From: Amanda Scholes on behalf of Planning.Responses
Sent: 01 February 2018 09:46
To: Planning Scanning
Subject: FW: DOC EP/159/17/DOC

From: Emma Weaver [REDACTED]
Sent: 05 January 2018 10:33
To: Anita Gardner
Cc: Barbara Haywood
Subject: DOC EP/159/17/DOC

On a personal matter and not one of Caldotec, I wanted to get clarification from you on the above mentioned application. I am concerned to see that they have asked to amend the planning approved drawings relating to the boundary wall. The application is asking to retain the rendered wall to our boundary rather than as approved, to have this in flint.

Drawing No. 217/536/6A

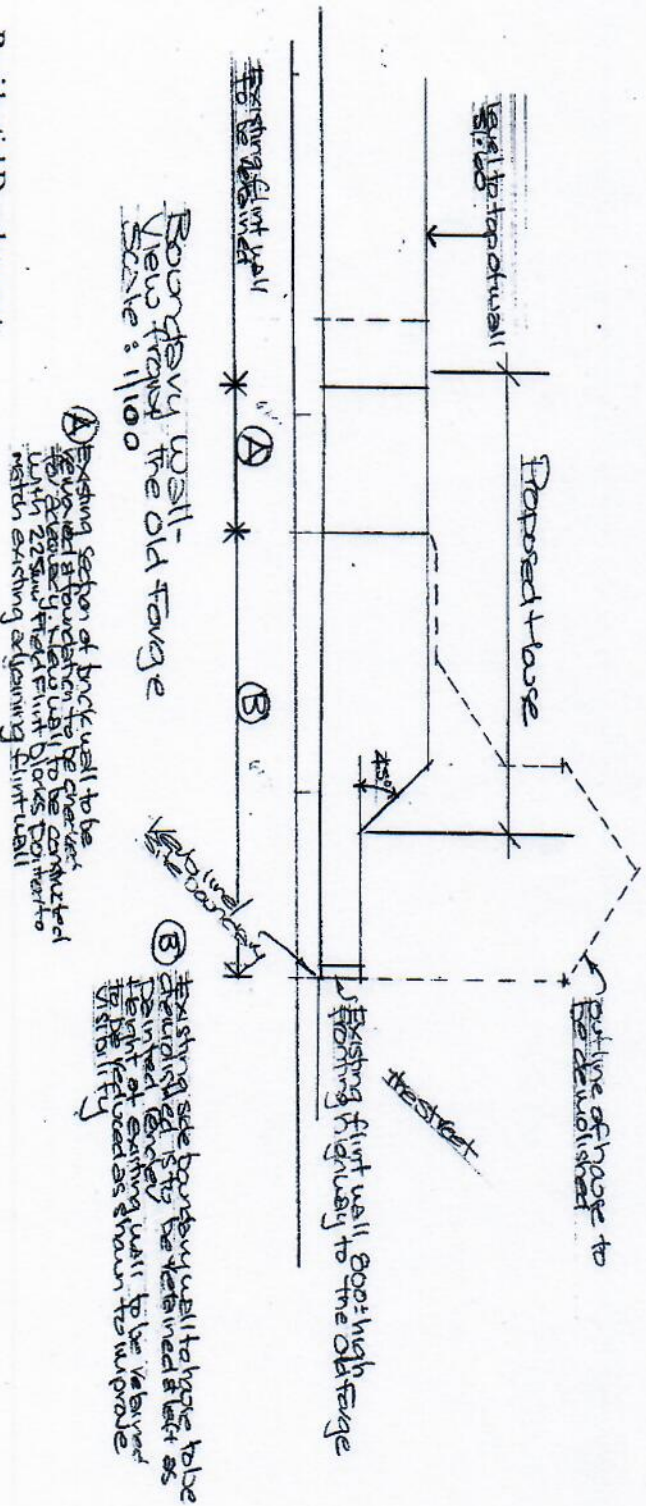
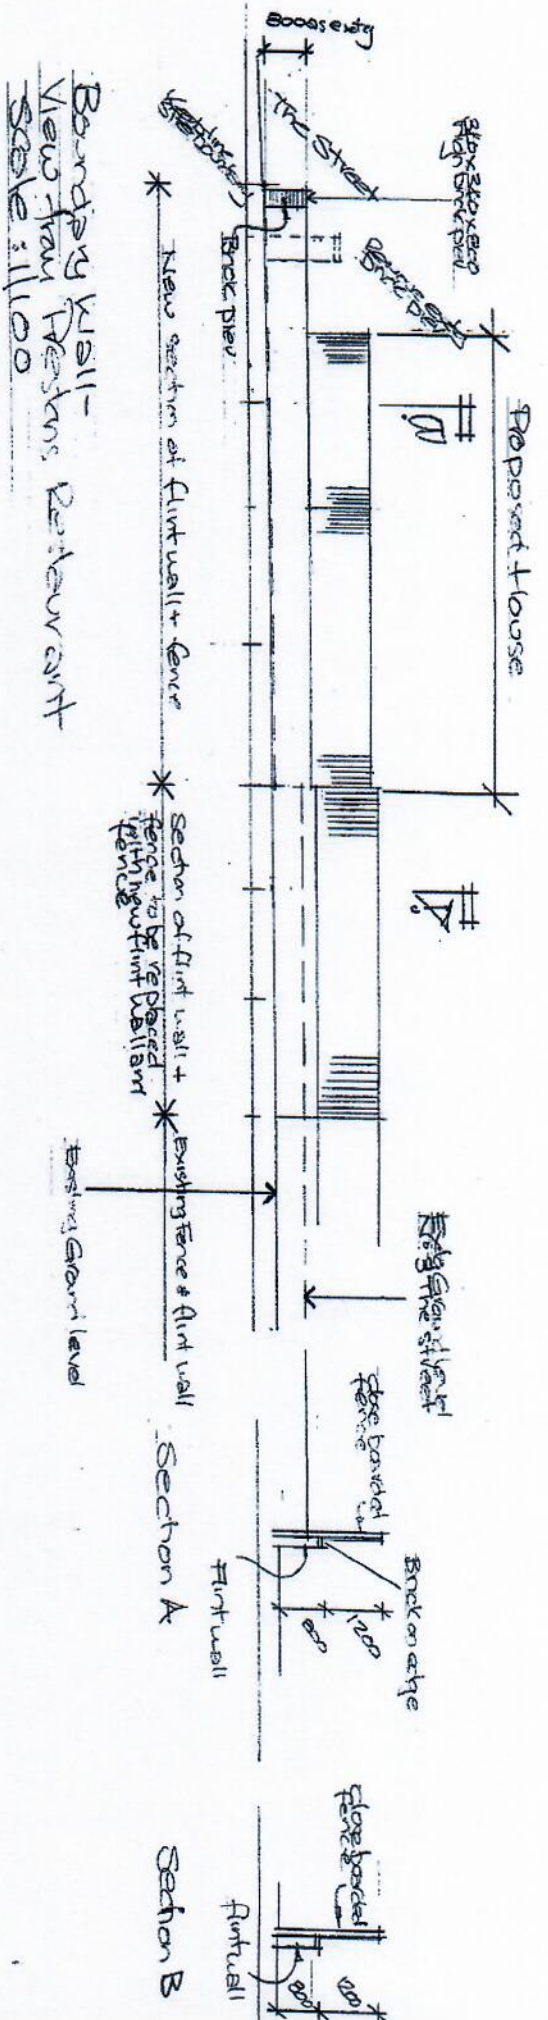
Firstly should this not be a Non material amendment? And secondly, I feel the mix of materials along the boundary wall between the site and The Old Forge and Forge House will look untidy and not in keeping.

The rendered part was purely there as this was part of the existing house. Now that the house has gone, I do not feel that keeping this rendered part is acceptable.
